Drafted 28 September 2011

**Planning Application, Ribble Valley District
D3-11-0526 Acorn Cottage, Back Lane, Rimington**

Drawing Number
TRI-0676_07

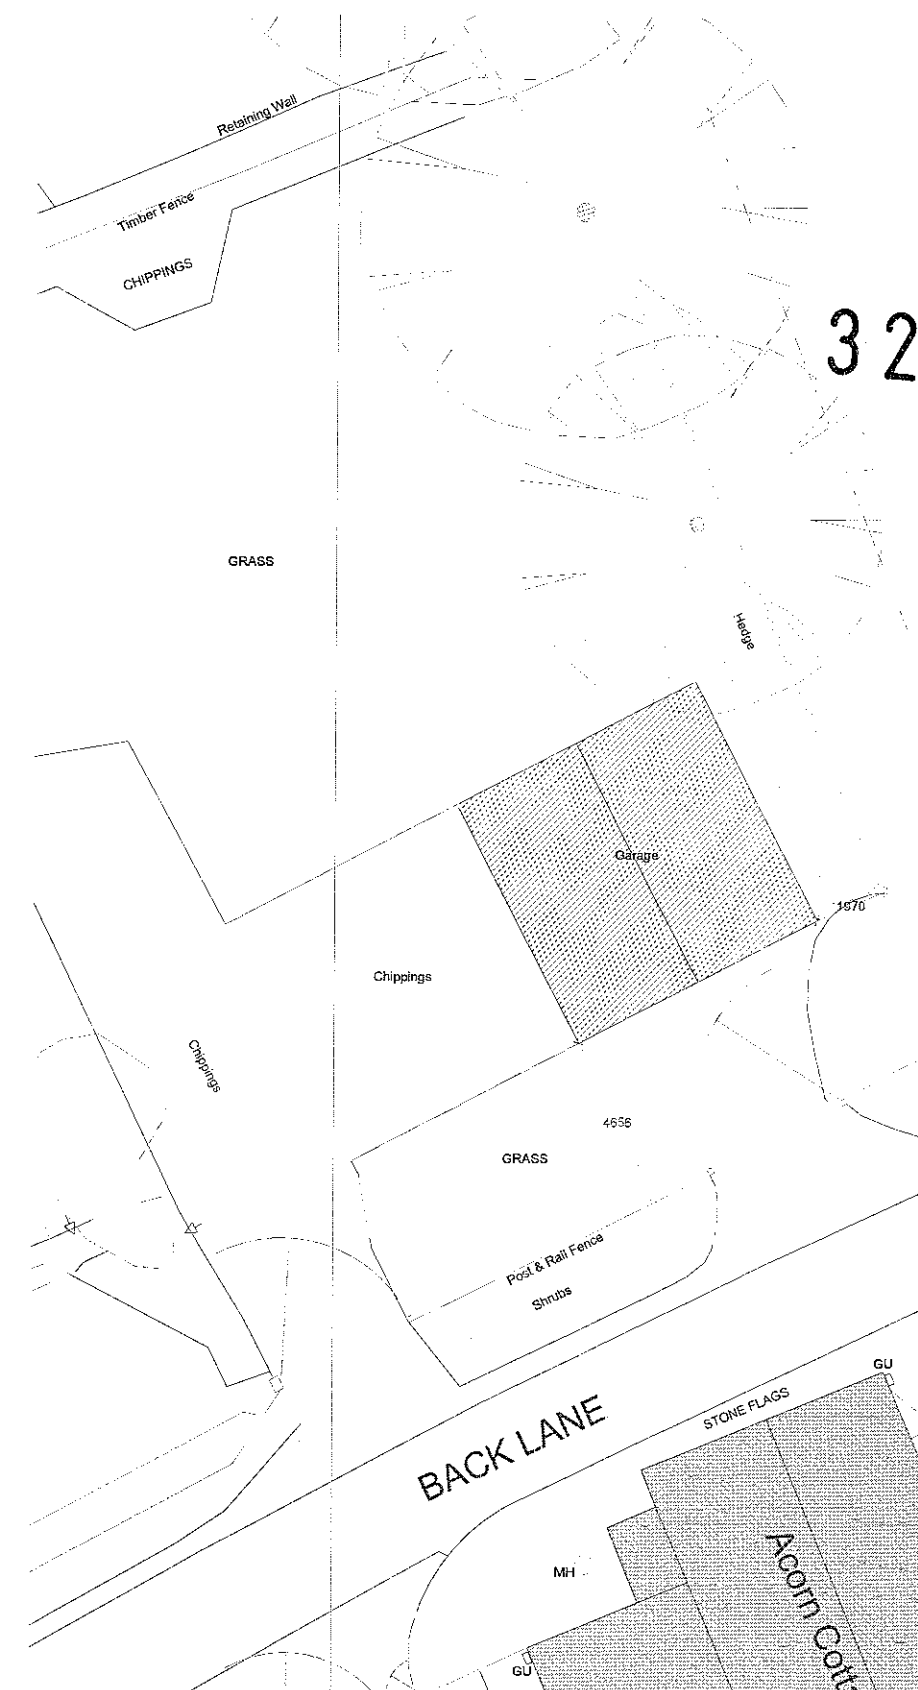
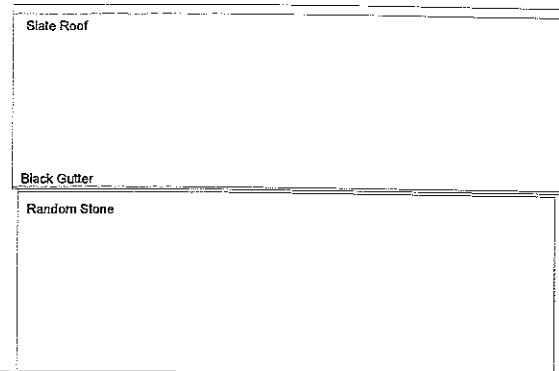
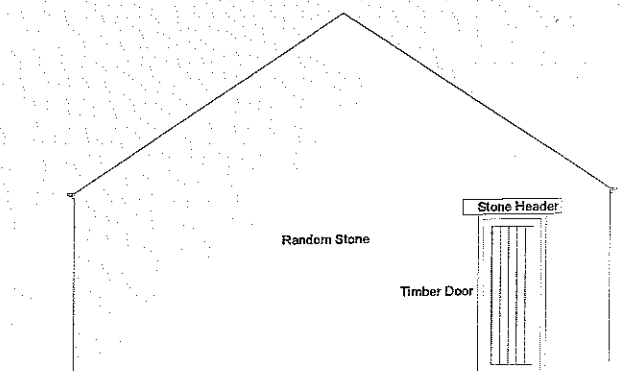
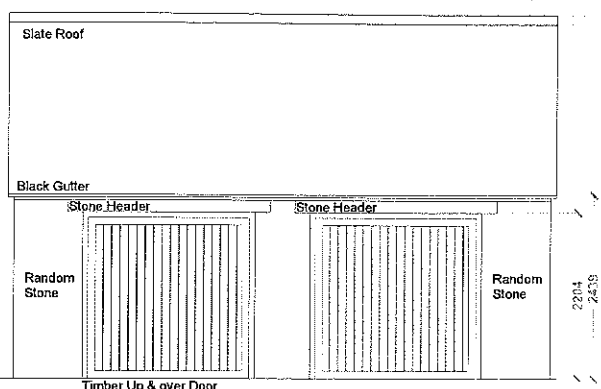
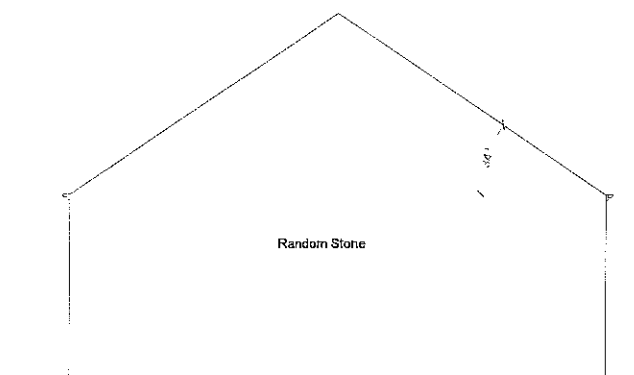
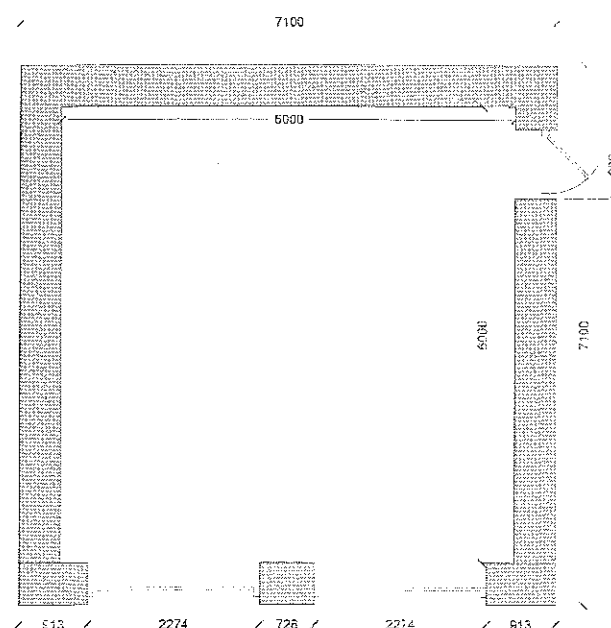
The Applicant has indicated that there will be a detached double garage, with additional parking on the approach, sufficient for three vehicles. I am satisfied that this can be achieved and that the development of the existing access to the north side of Back Lane is safe. While the garage is separate from the property and residents are required to cross Back Lane, this does not present any significant highway safety issues as the road is lightly trafficked, vehicles speeds have been observed to be low and there is adequate visibility.

Drawing Number
TRI-0676_06

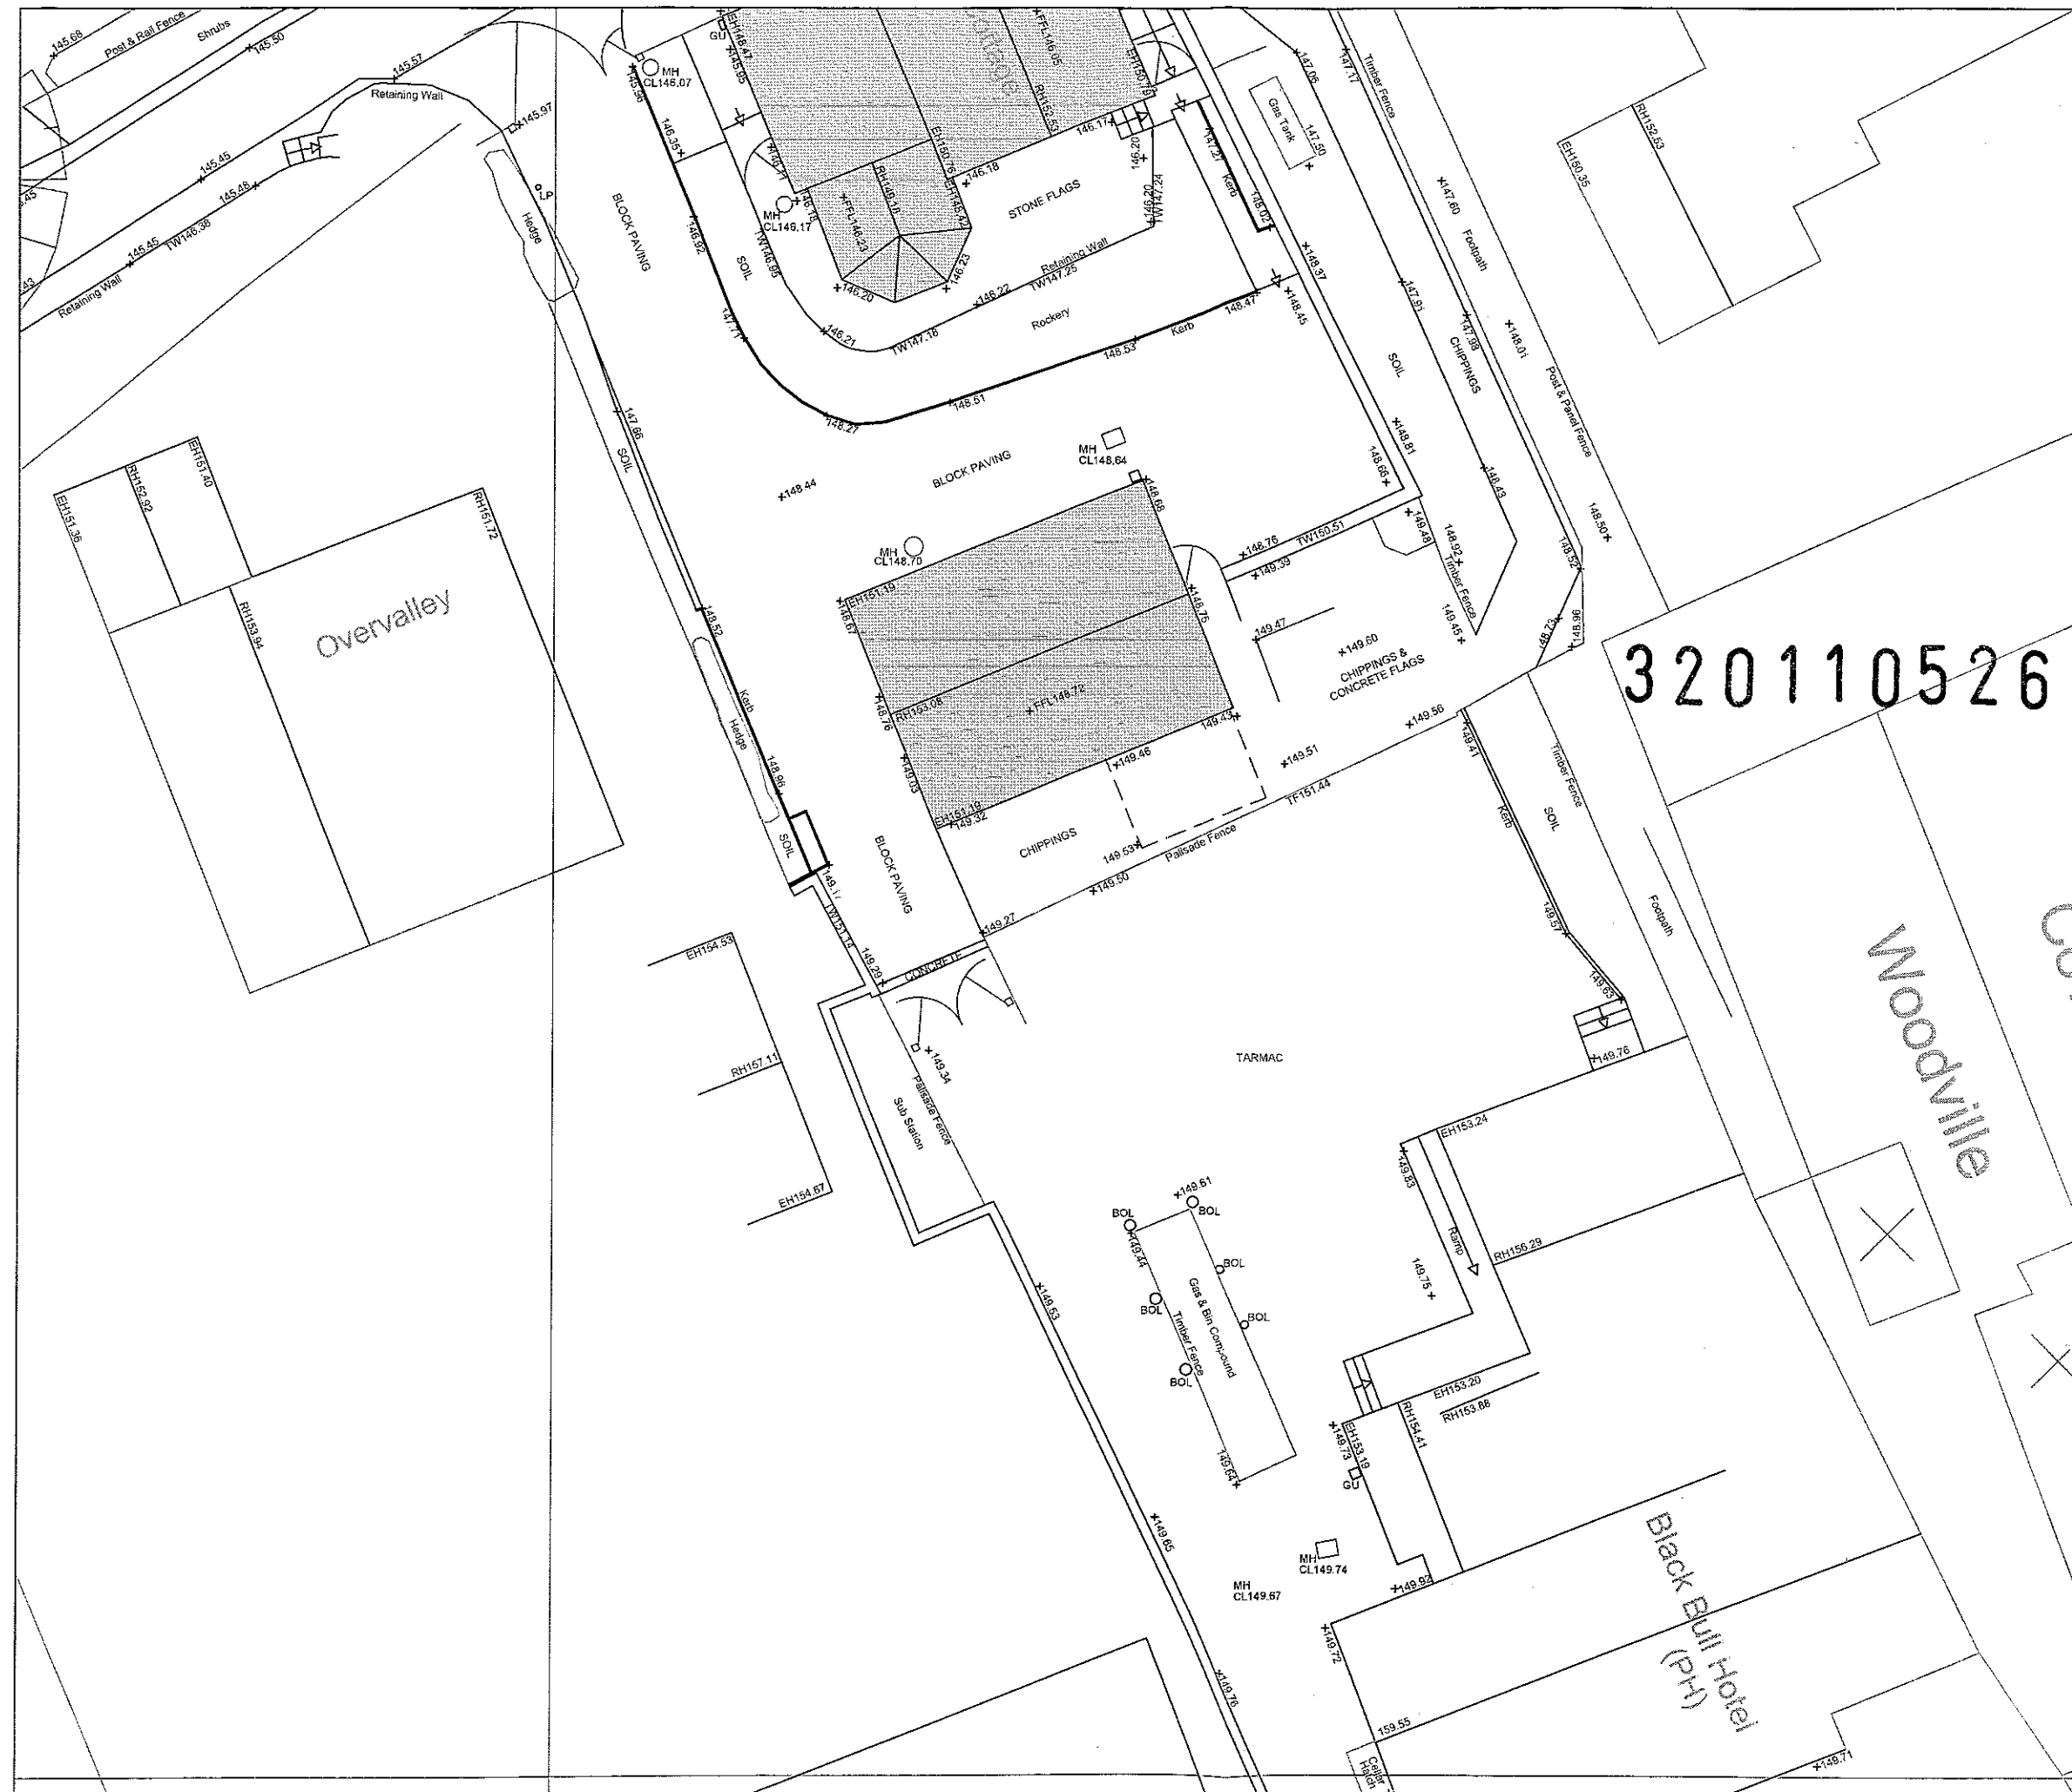
The new cottage has two off road spaces against the westerly gable. Once again I am satisfied that this level of provision is sufficient for the size and function of this property.
